Camellia and Rosehill Recycled Water Scheme

Preferred Project Report

Date: 19 March 2009
Reference: RRW-01-RP-E-00031
Revision: 0

Appendix A Revised plant layout and elevation plans

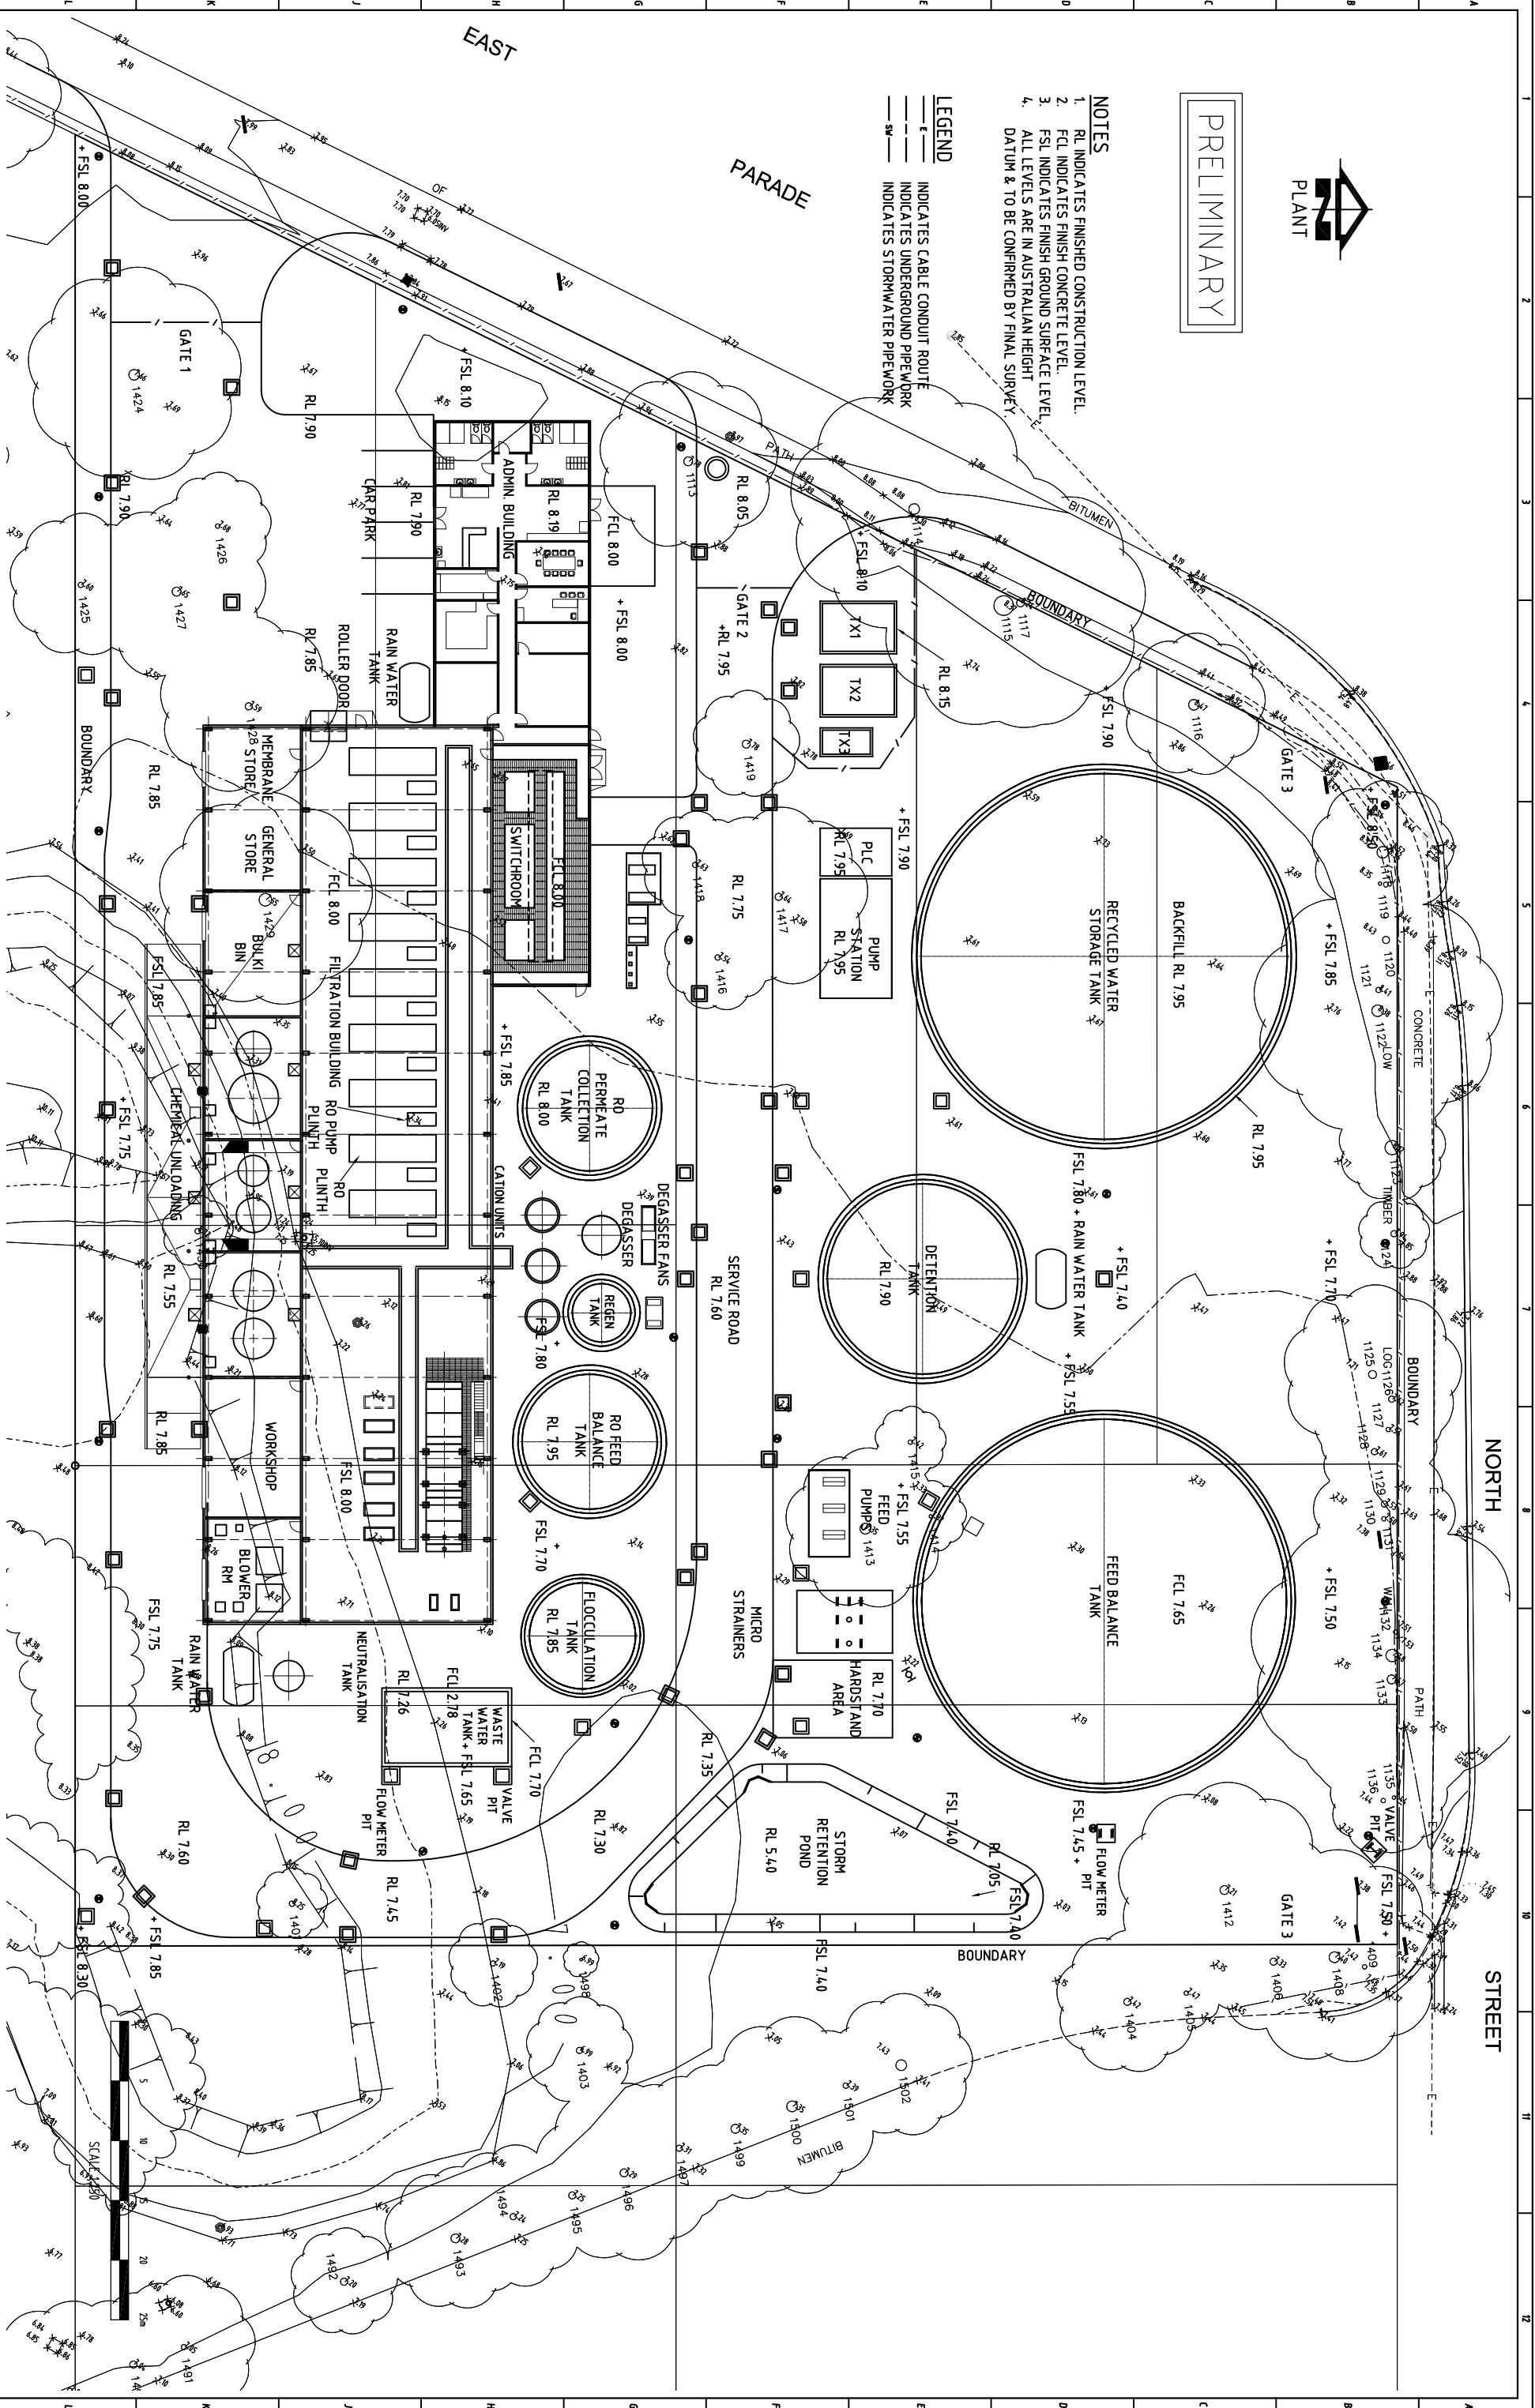
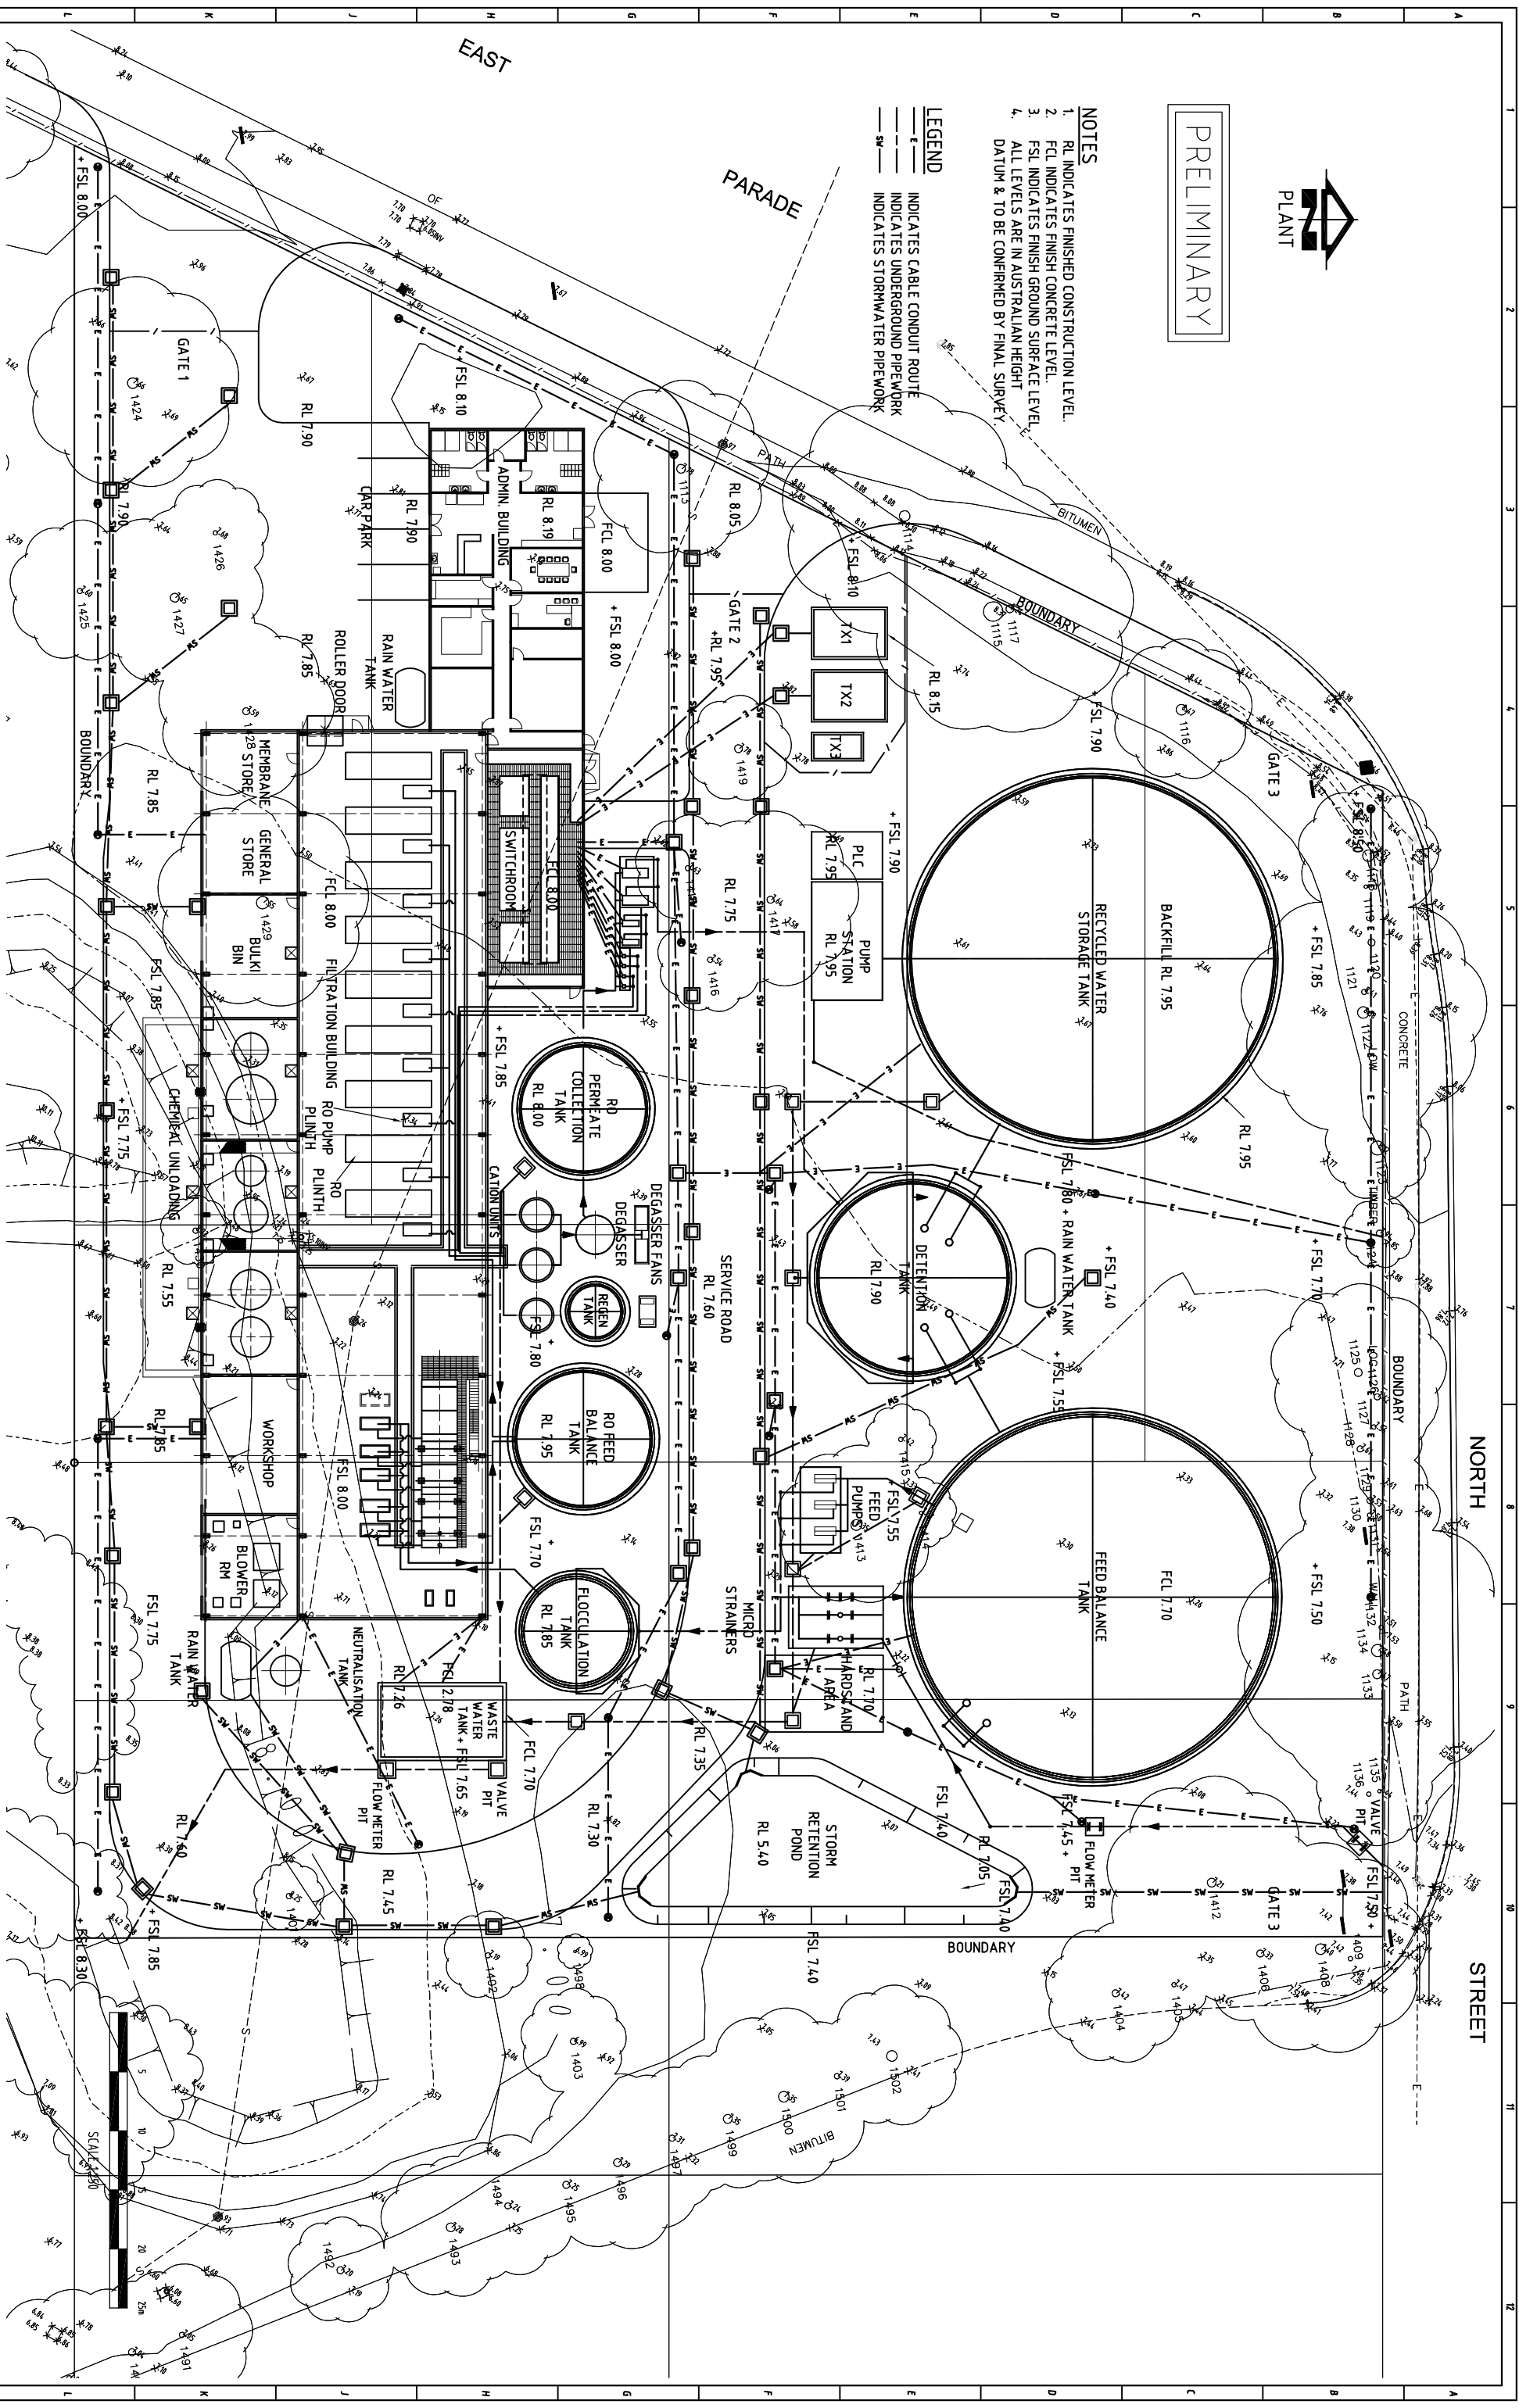
The plant design has been advised to accommodate the requirements of the energy provider. The original proposal included a high voltage transformer located immediately east of the main filtration building in the south eastern portion of the site. The revised design now includes three low voltage transformers (2 x 1250kVA and 1 x 500kVA) located on the western boundary of the site off East Parade. The revised transformer location and configuration is outlined in the revised plant design plans shown in **Figure 2-1** below. A detailed plan of the revised plant layout is provided in **Appendix A**.

The revised location has been chosen in between the recycled water storage tank and the main filtration building directly adjacent to the transformer as shown in **Figure 2-1** and **Appendix A**. At this location, line of sight between the pump station and the residences is limited by recycled water storage tank, detention tank and feed balance tank, providing noise attenuation for the adjacent residents along North Street.

In order to reduce energy requirements the heights of the recycled water storage tank, feed balance tank and detention tank have been reduced. To maintain storage volumes, the diameters of the tanks have increased accordingly, as shown in the revised plant layout plan **Appendix A**.

The revised layout potentially affects the visual amenity of the site. In general, the heights of all the tanks, buildings and other structures proposed at the Fairfield water recycling plant have been reduced in the revised design, and the overall silhouette of the plant will be more compact. The original and revised section plans are shown in **Figure 2-2** below. A revised elevation plan for thee plan is provided in **Appendix A** of this report. A summary of revised heights and height changes is provided in **Table 2-1** below.
